Application Ref:	3/2025/0417			 Ribble Valley Borough Council www.ribblevalley.gov.uk
Date Inspected:	13/8/25	Site Notice:	11/7/25	
Officer:	BT			
DELEGATED ITEM FILE REPORT:				APPROVAL

Development Description:	Planning permission for proposed repair, internal and external alterations, amendments to outbuilding to listed building, new external garage, two air source heat pumps.
Site Address/Location:	The Court House, Gisburn Road, Bolton by Bowland, BB7 4NP.

North Elevation

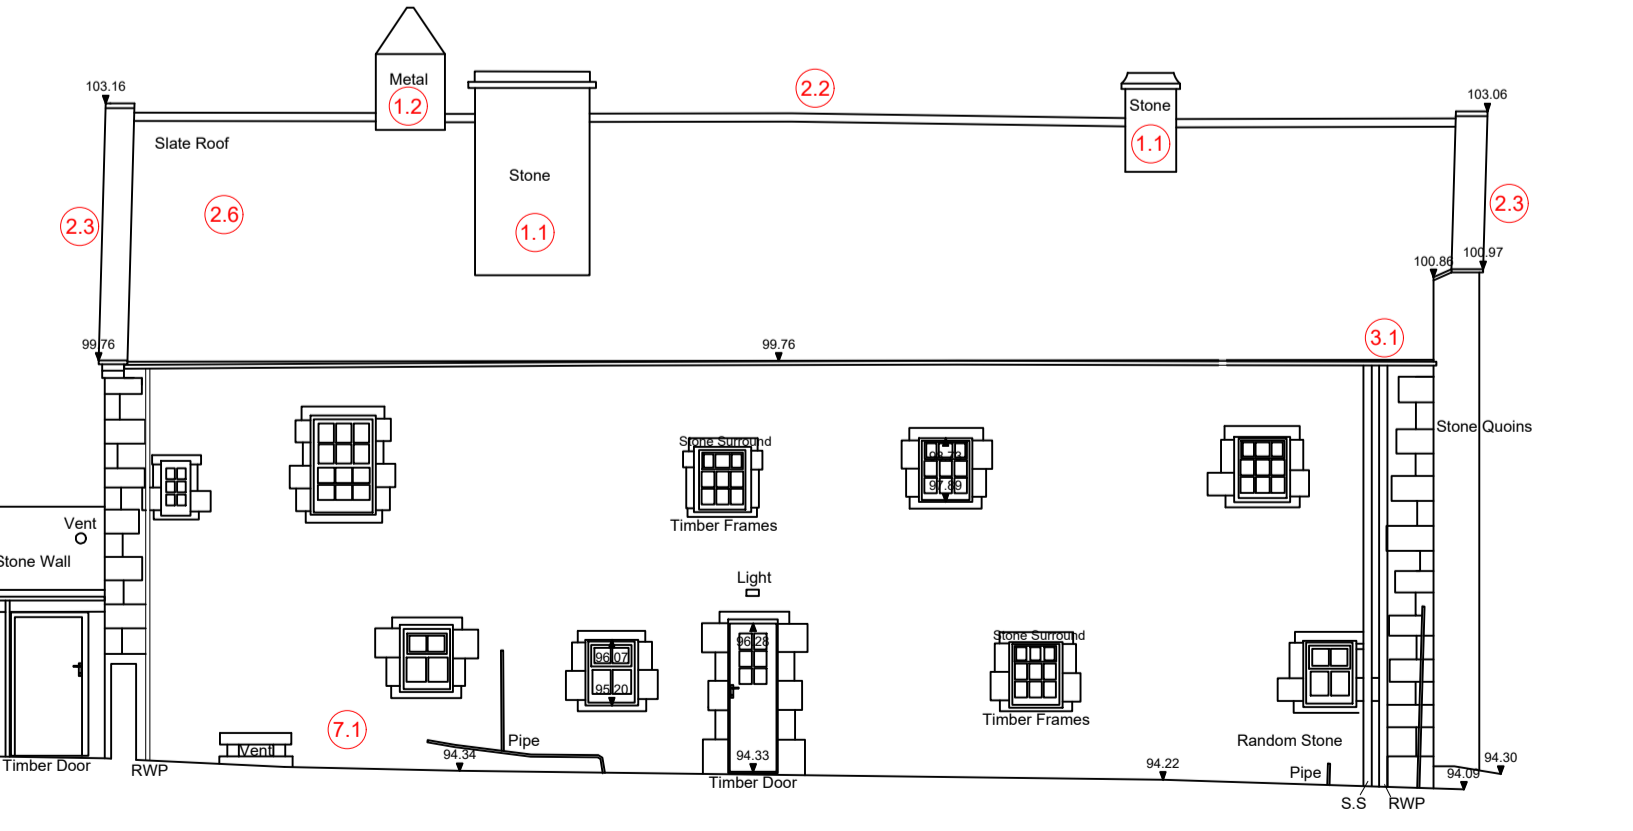
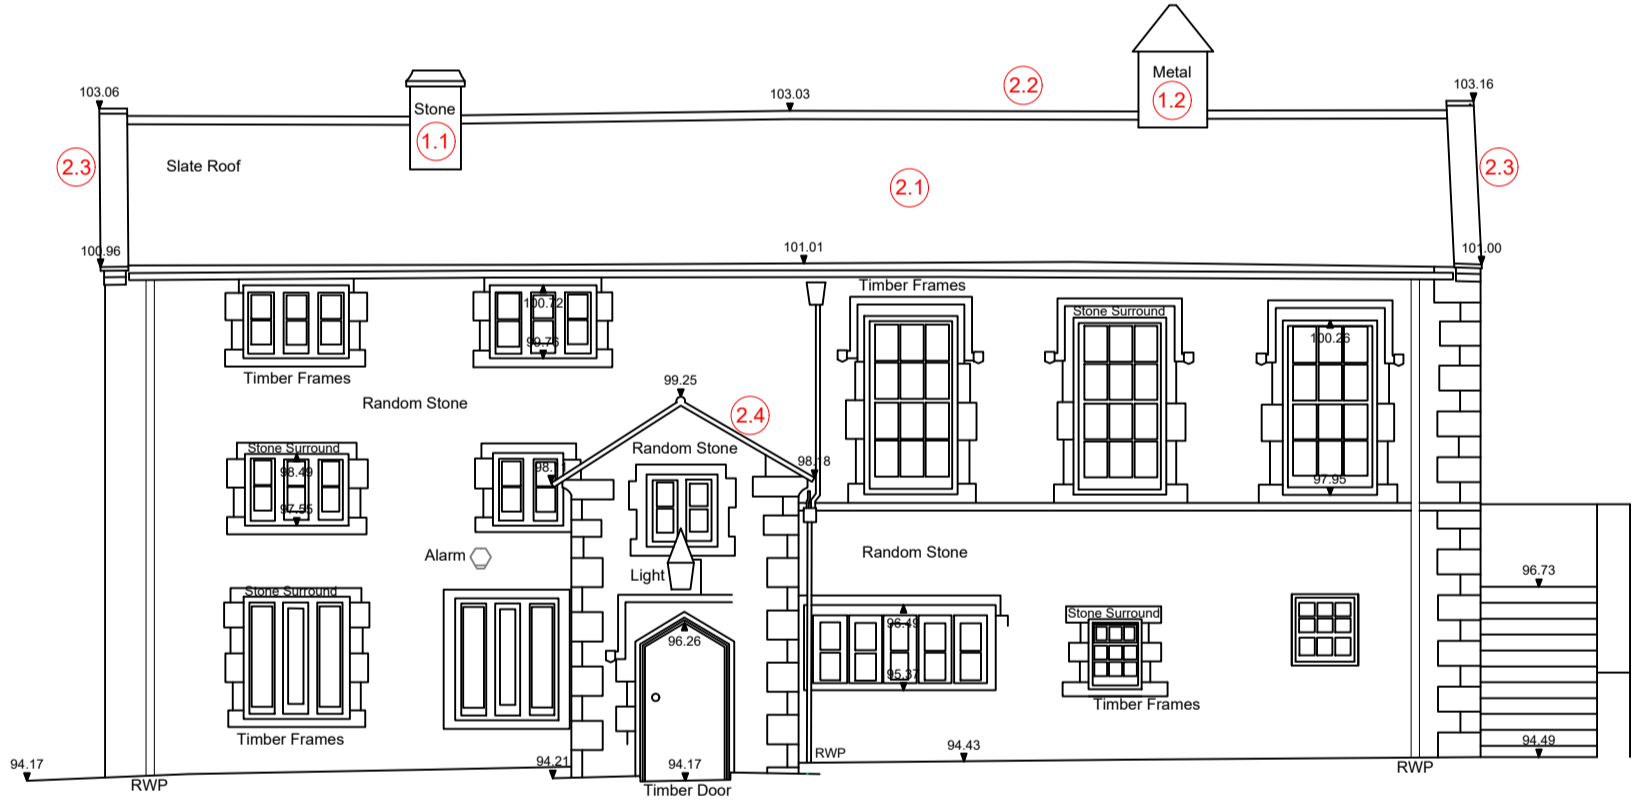
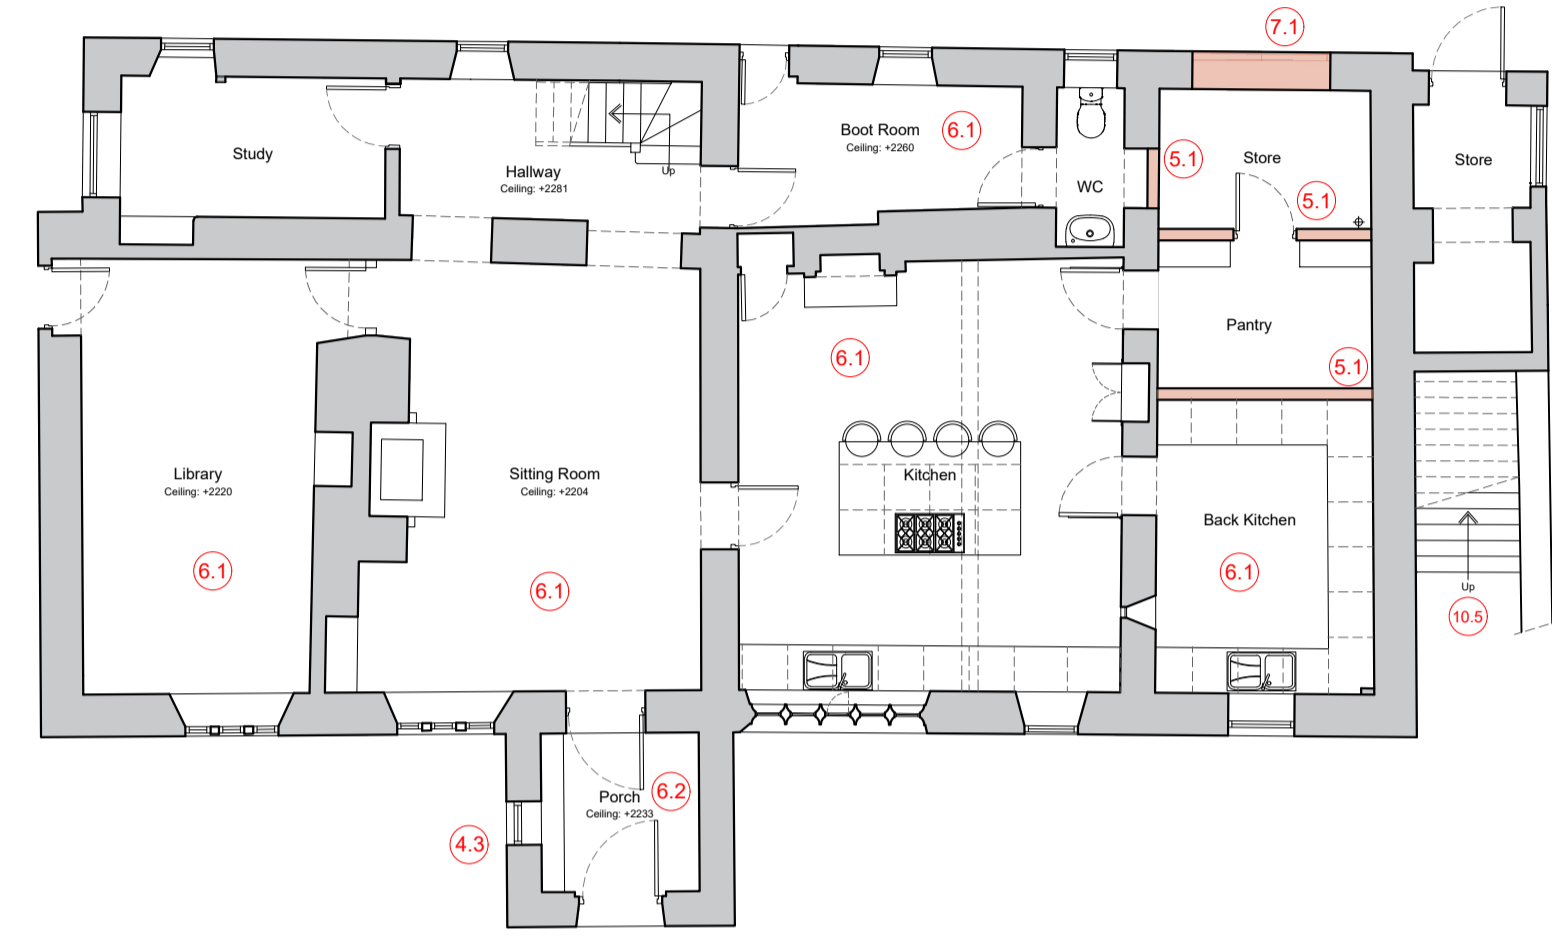
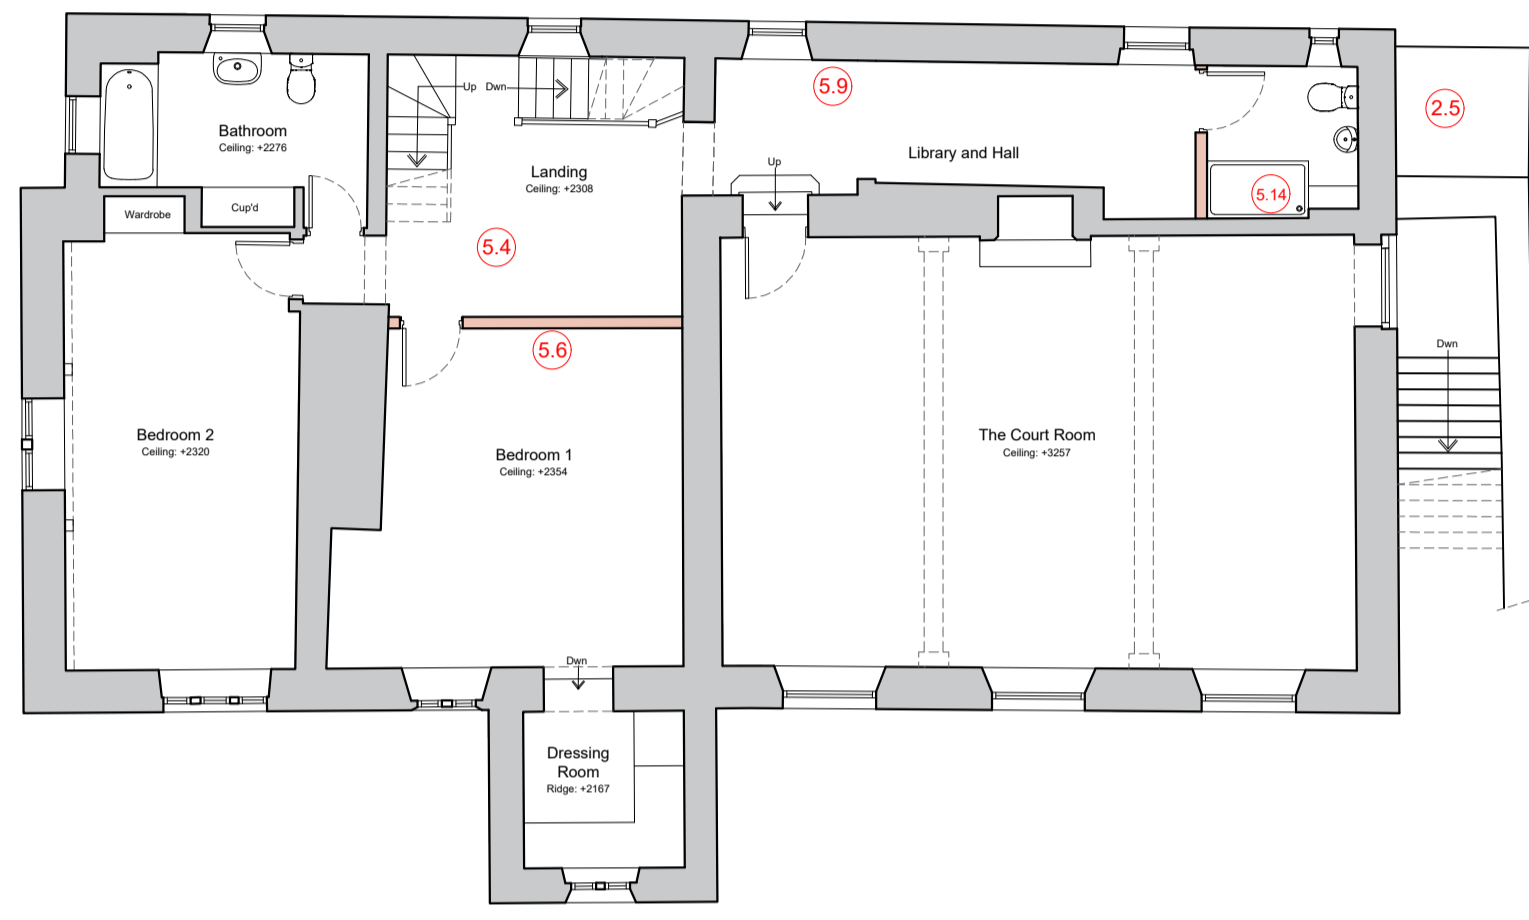
addition, the proposal seeks to remove an incongruous modern window and shutter from the rear North-eastern elevation of the dwelling and infill the remnant opening with matching stonework which would deliver a further enhancement to the external appearance of the building.

In this instance, the proposed works of repair to the application property's roof, rainwater goods, external walls and windows would deliver a visual enhancement to the external appearance of the historic dwelling. In addition, the proposal seeks to remove an incongruous modern window and shutter from the rear North-eastern elevation of the dwelling and infill the remnant opening with matching stonework which would deliver a further visual enhancement to the external appearance of the application property.

Outbuilding Floor and Lining Wall.
Scale 1:25

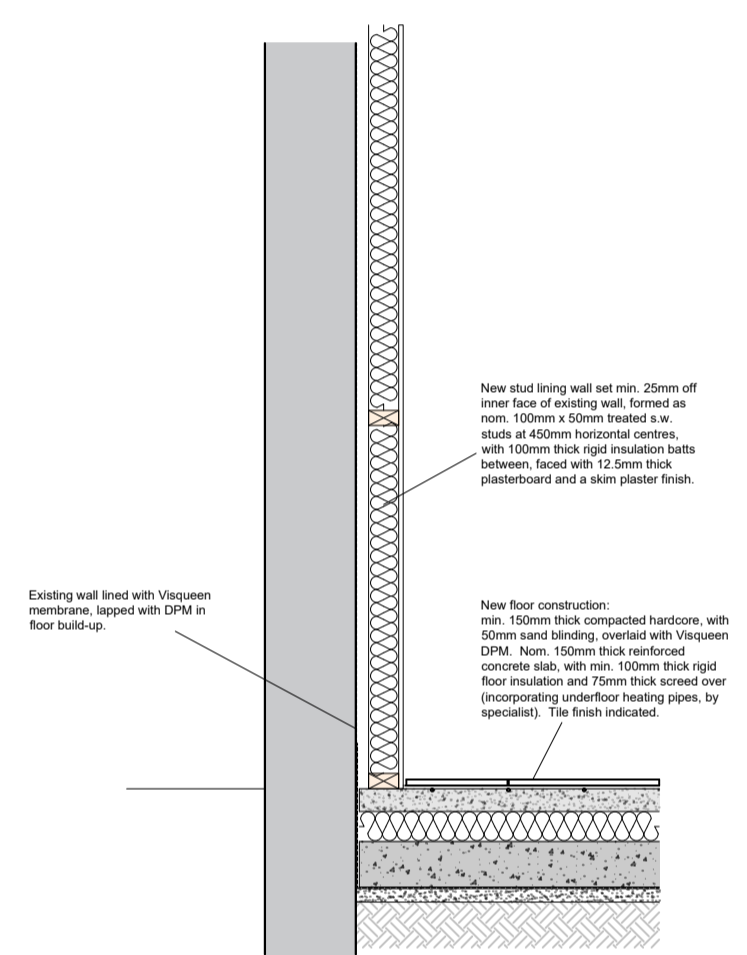
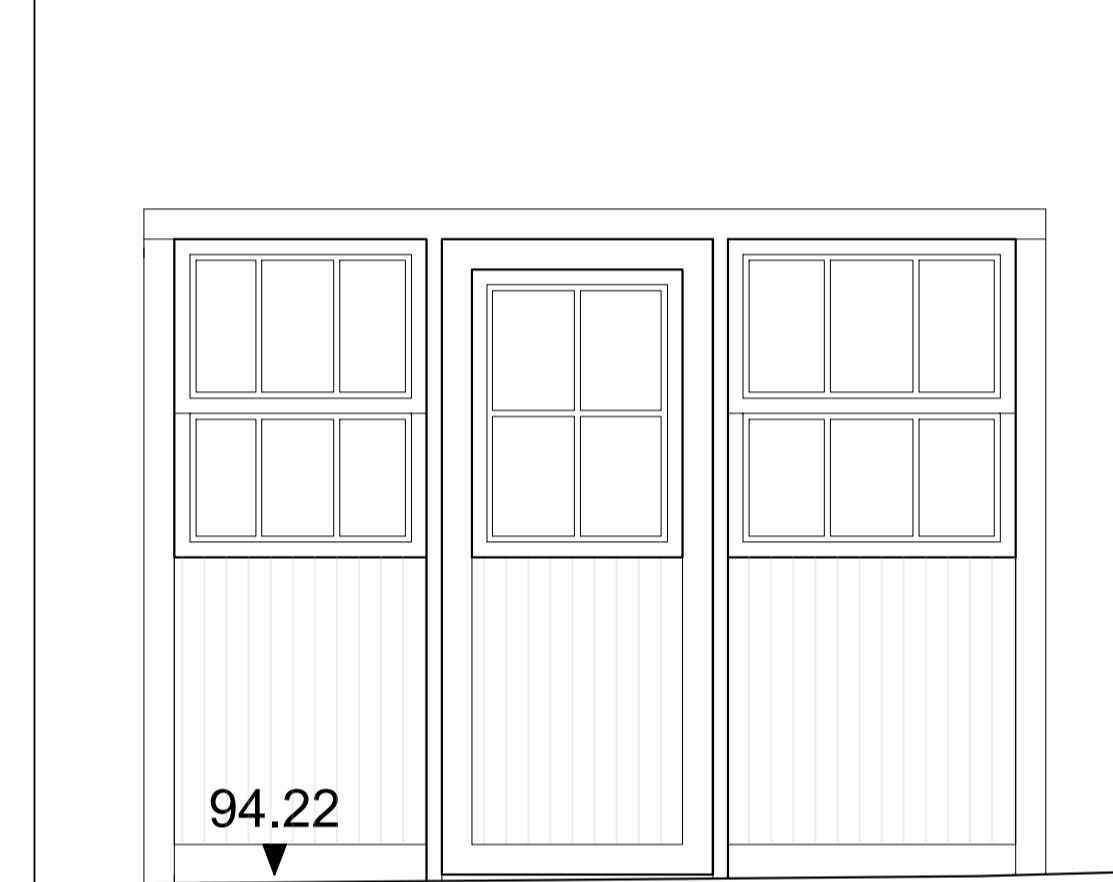
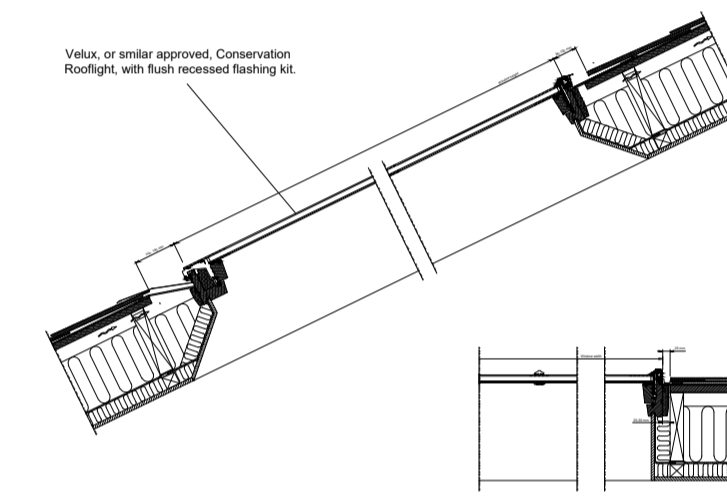
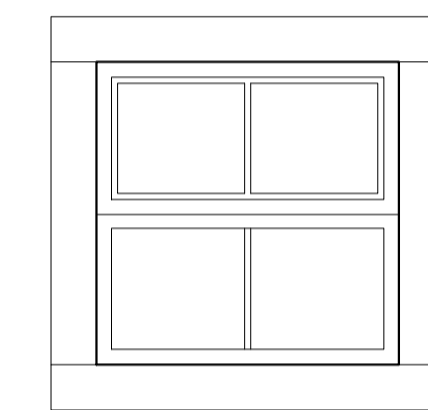
The proposed ASHP have been relocated to the northern elevation of the outbuilding away from the dwelling which will have less impact than previously proposed. Whilst it would be preferable for full details of the ASHP to be provided with the application, in light of the revised siting the LPA is content for this to be secured by condition. The alterations to the outbuilding involve the provision of conservation rooflights, external door alterations and a new window installed in the west elevation. The submitted details show this to be a top hung casement but this is considered to be inauthentic and harmful to the building character. Subject to a suitably worded condition that secures an alternative design for the new window, which the applicant has agreed to, the proposal would cause a low level less than substantial harm to the significance of the listed building through limited loss of historic fabric of the outbuilding and installation of ASHPs and the visual impact this would have if installed.

The conversion of the existing workshop / store building to a utility and plant room would involve some external alterations to the curtilage listed building however the door and window openings proposed for the South-western elevation of the building would be formed through existing door and window openings and the new window opening proposed for the building's North-western elevation would be in keeping with both the proportions and design of the existing windows within the North-western gable end of the application property. Furthermore, the two new rooflights proposed would comprise a Conservation style design which would allow for seamless integration within the building's roofspace. As such, it is not considered that the works of conversion to the outbuilding would detract from its historic character. The two air source heat pumps would be modern additions to the grounds of the historic property however these would be modest features in terms of their cubic volume would remain predominantly screened from public view by virtue of their siting to the rear of the application property. As such, the addition of the proposed microgeneration equipment to the site is considered to be acceptable.
